DECISION DELEGATED TO HEAD OF PLANNING

Application No: H05-0353-24 **Applicant:** Mr & Mrs Jones

Proposal: Change of use of part of paddock to residential curtilage, extensions and alterations to dwelling including new gated entrance

Location: Ravensdale Bens Gate Fleet

TITLE: Elevations - As Proposed (Sheet 1 of 2)

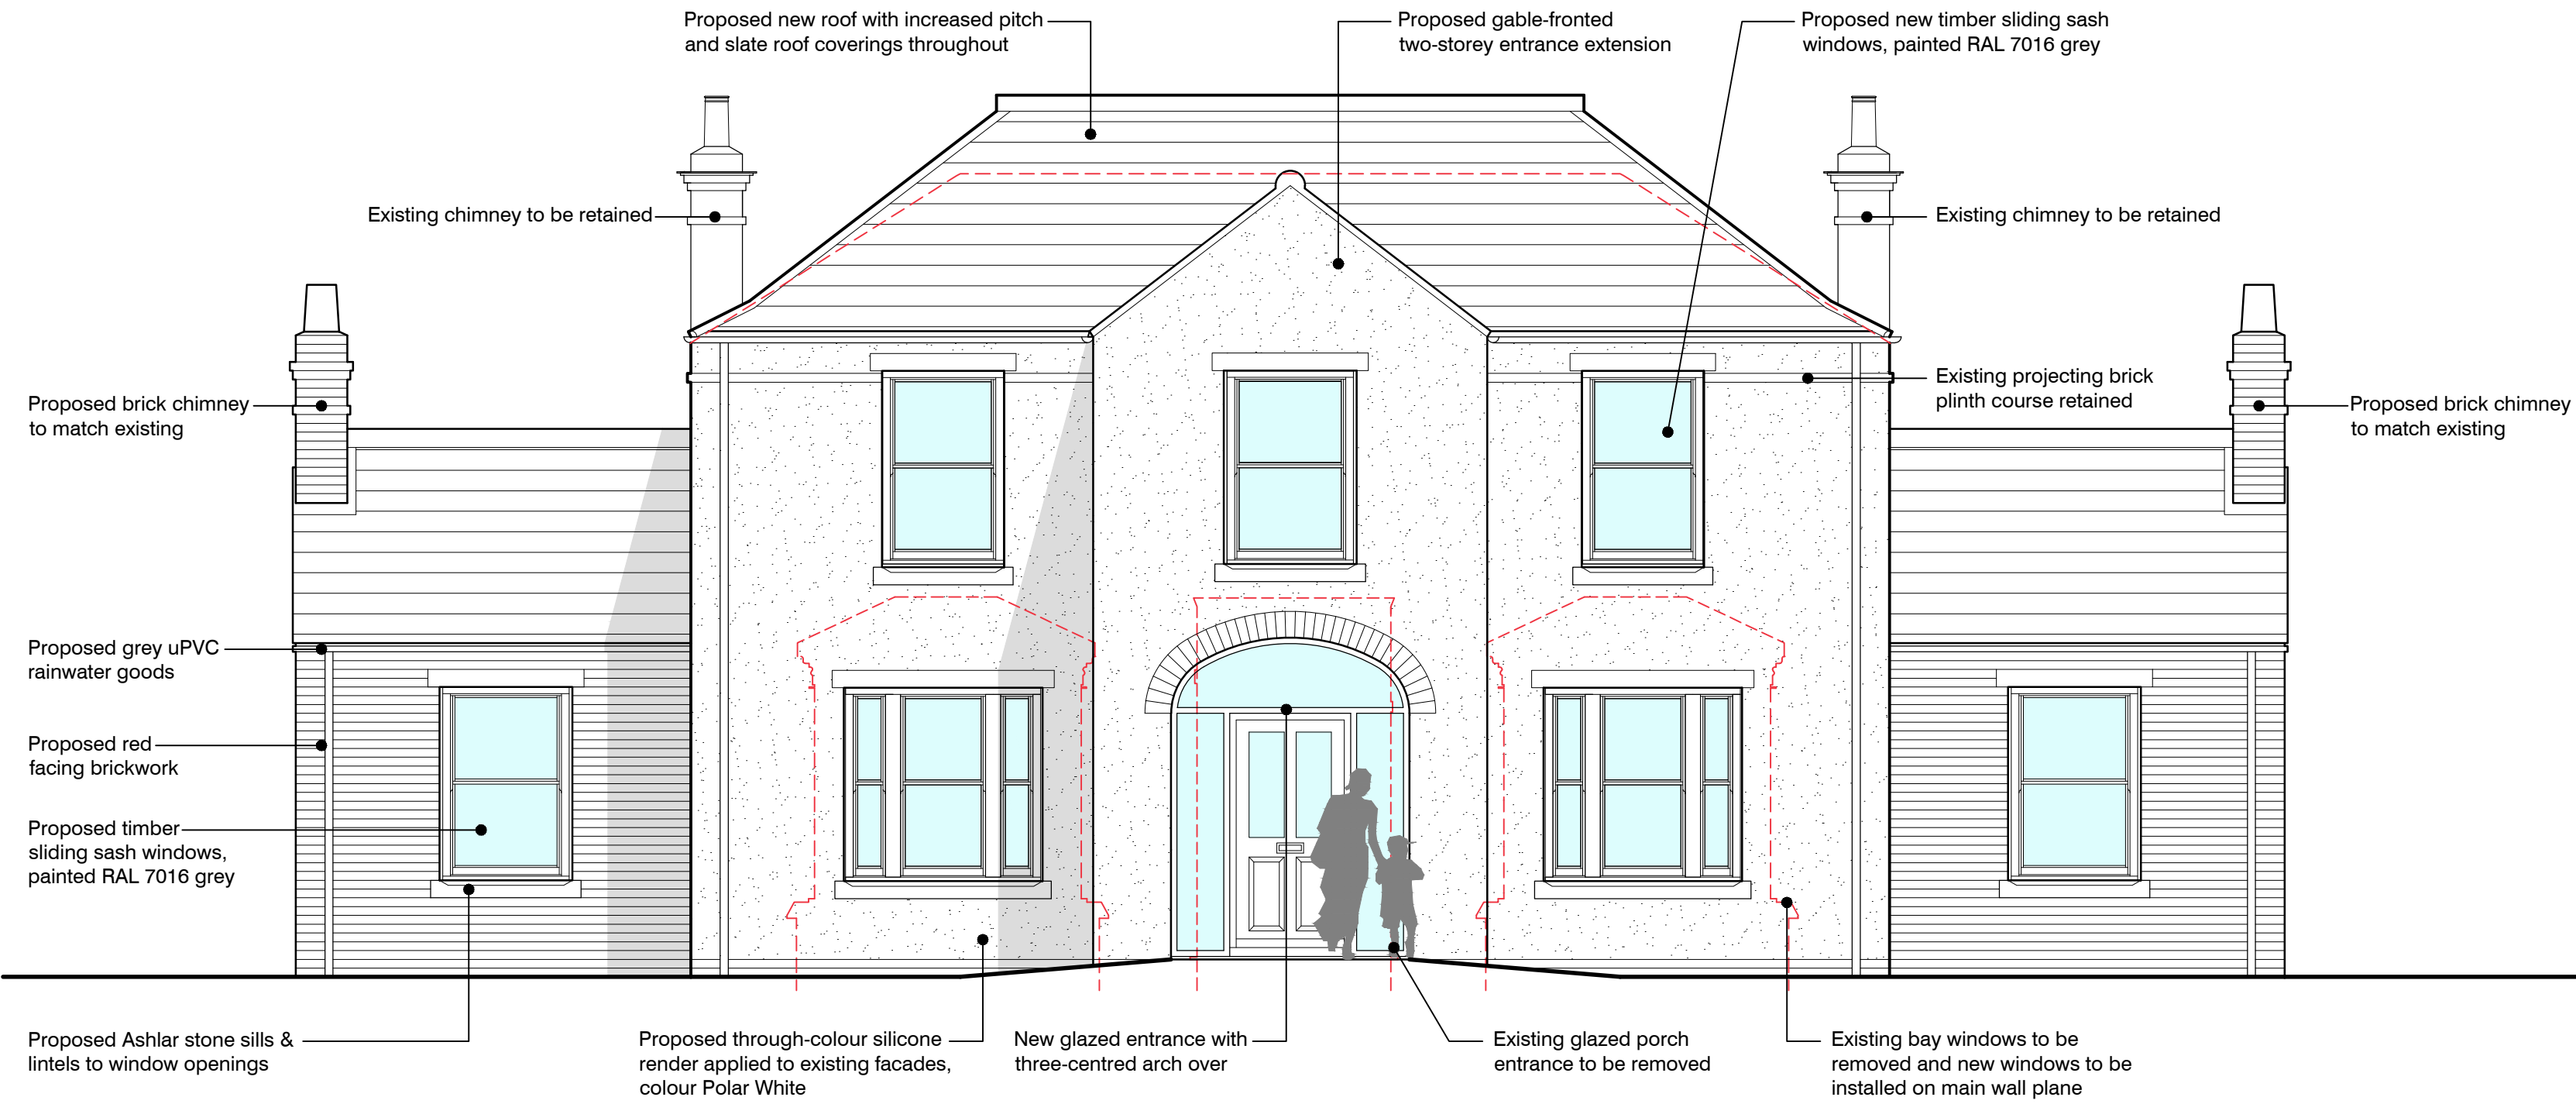
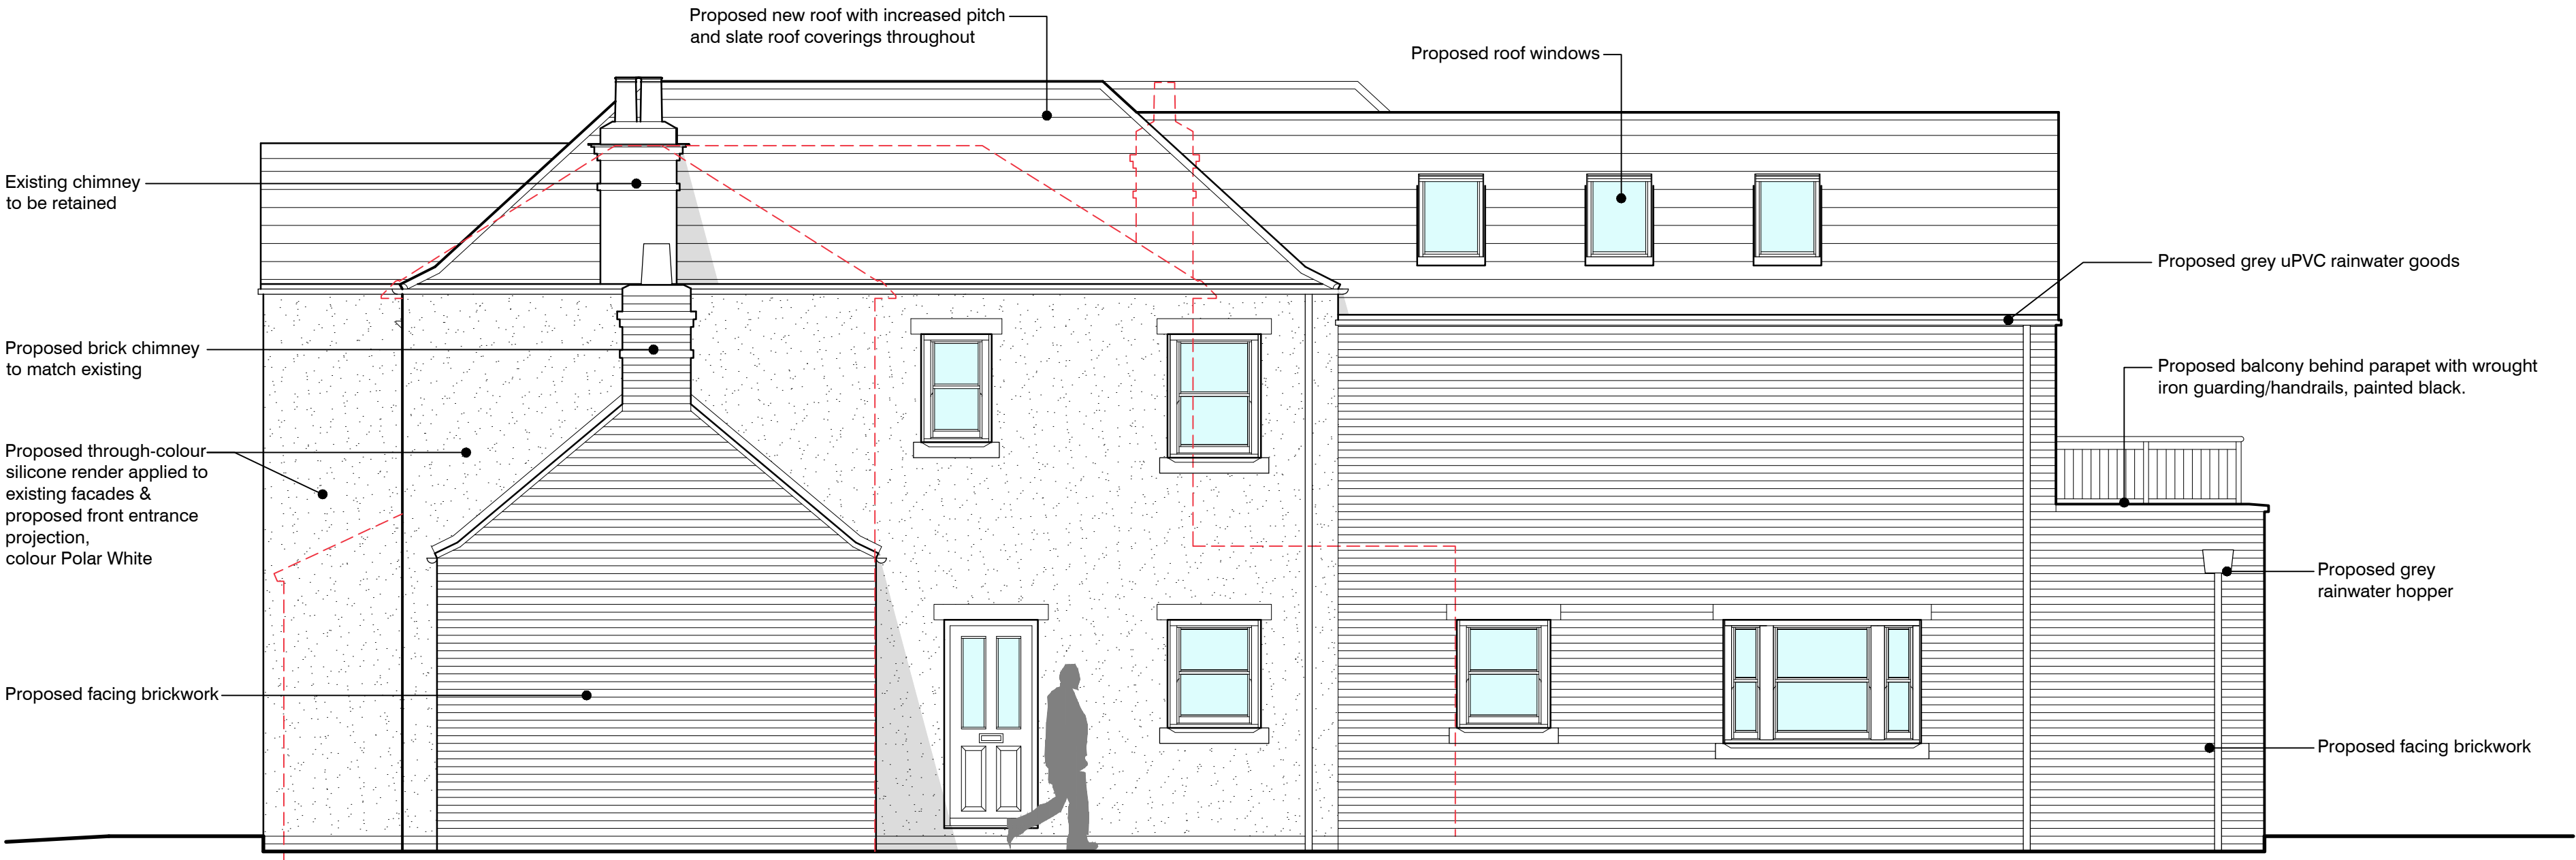
Within the centre of the front elevation, a proposed two storey gable extension will be located to allow for further internal changes and to allow for the dwelling to appear modernised, when viewed externally. The existing chimneys are to be retained as well as the existing projecting brick plinth course. In a similar light to the side extensions windows, the windows across the front elevation will be replaced with Timber sliding sash, painted RAL 7016 grey. A notable change will be the new roof, which will feature an increased pitch and slate roof coverings throughout. This aspect of the development should allow for increased internal space in respect of height within the dwelling, as well as allowing the extensions to appear more subservient; albeit, the development when viewed as a whole can be considered relatively substantial. The changes made to the front elevation of the existing property, including the extension detailed, is therefore considered to be acceptable and should not materially harm the street scene or locality; albeit, comprising a notable change.

The east side elevation would feature four new windows and a door, in addition to three roof lights within the rear extension. These windows provide natural light into the extension and new rooms. The roof in this area will also be increased in the same way previously detailed in relation to the front elevation. On the west elevation there will be three new windows on the first floor, one roof light, two thin windows (one to the ground floor and one to the first floor), as well as a proposed bay window with canopy and porch, comprising a new side entrance. These changes are all considered to be acceptable as the windows will create openings for natural light with additional access doors. The bay window and canopy are also an acceptable feature and in any case cannot be viewed from

TITLE: Elevations - As Proposed (Sheet 2 of 2)

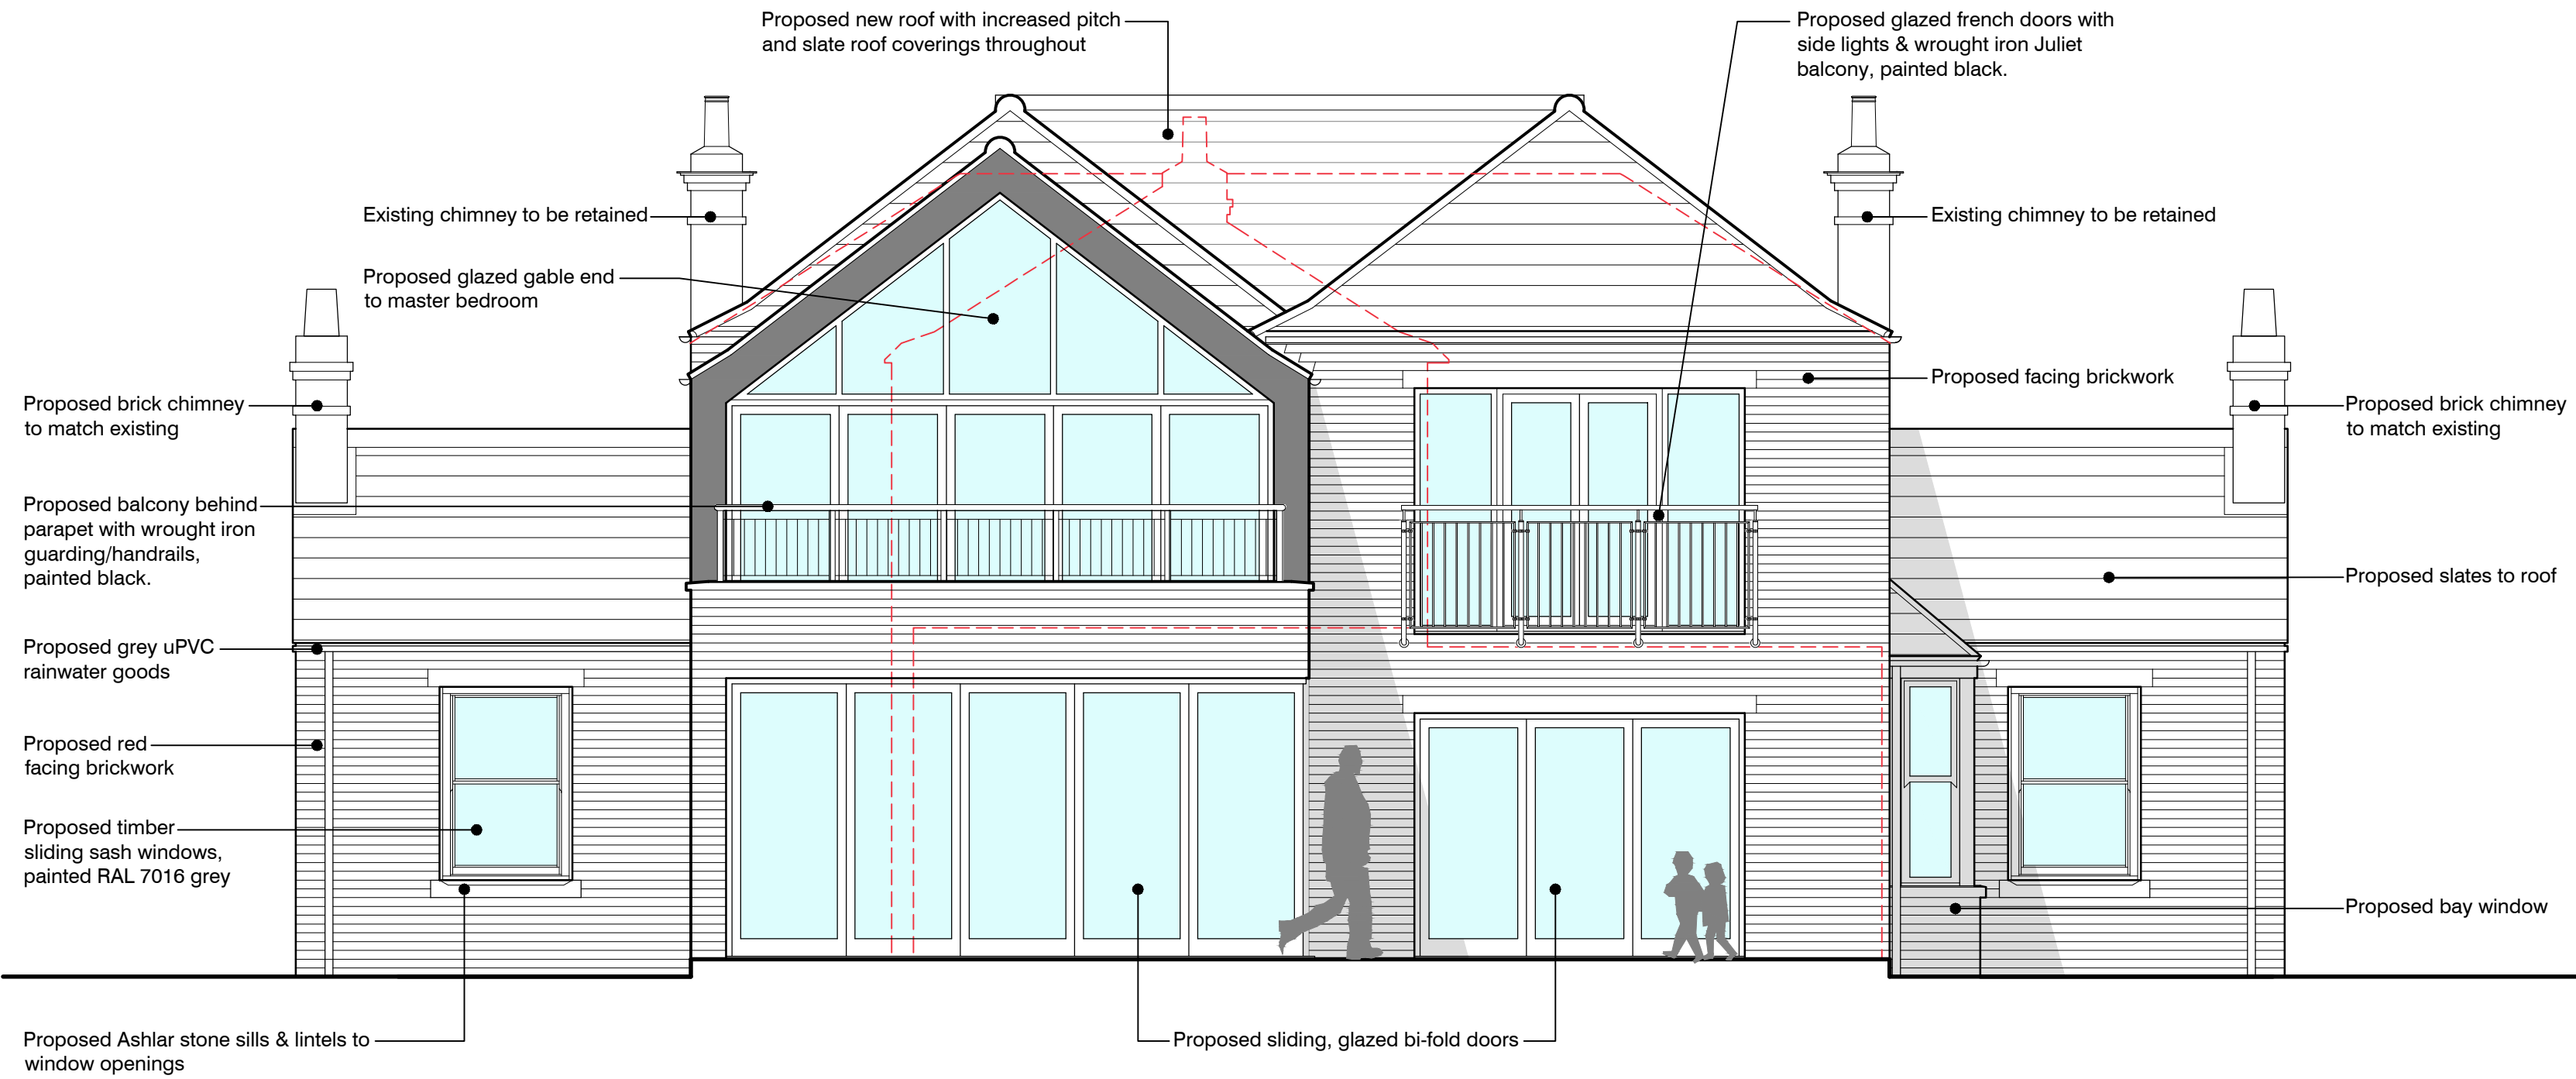
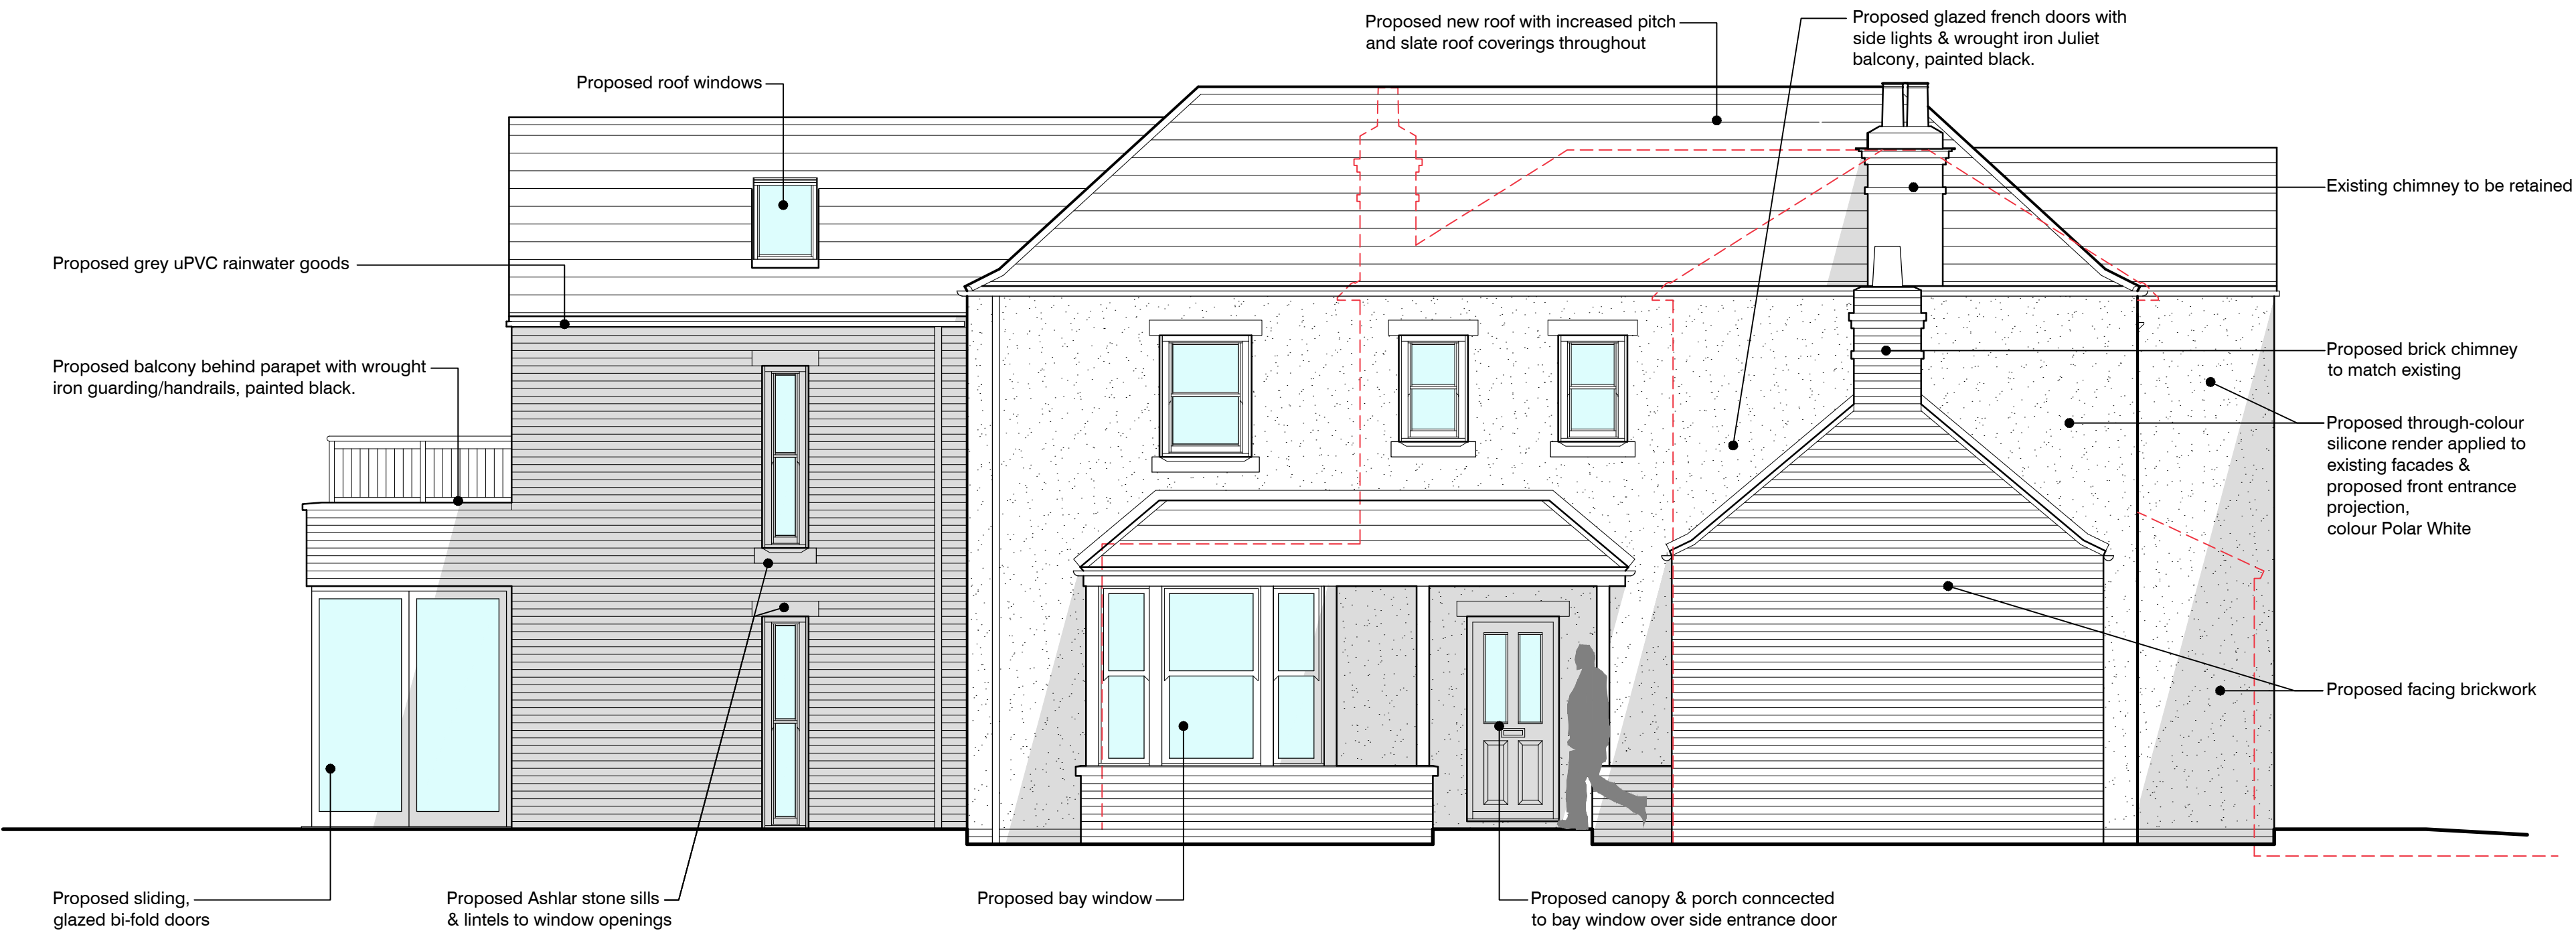
Finally, the most significant new feature is the rear extension. From the existing rear-most elevation, the extension will project by around 7800mm whilst also protruding from other elements of the existing elevations to differing degrees of set back. This would create additional floor space within the habitable areas downstairs, as well as on the first floor.

Whilst it could be considered that the extension from the rear elevation is significant in size, in comparison to the overall size and structure of the existing Ravensdale, it is considered to be proportionate in this instance. This will be constructed from red facing brickwork, with its most prominent features being the proposed gable end to the master bedroom; comprising large lazing throughout. These windows are not featured in other dwellings; however, will allow it to appear somewhat modern in its characteristics. Furthermore, it ensures there are minimal windows on the side elevations to limit any potential overlooking. Alongside this, there will be a proposed balcony operating for the master bedroom and a Juliet balcony for another bedroom. Both balconies will be made from wrought iron painted black. Although balconies are not common features within the area they should cause minimal harm. There will also be proposed sliding glazed bi-fold doors across the ground floor section of the rear elevation for access outside as well as providing natural light into the open plan rooms. Overall, the alterations to the rear elevations including the design of the extensions are considered acceptable.
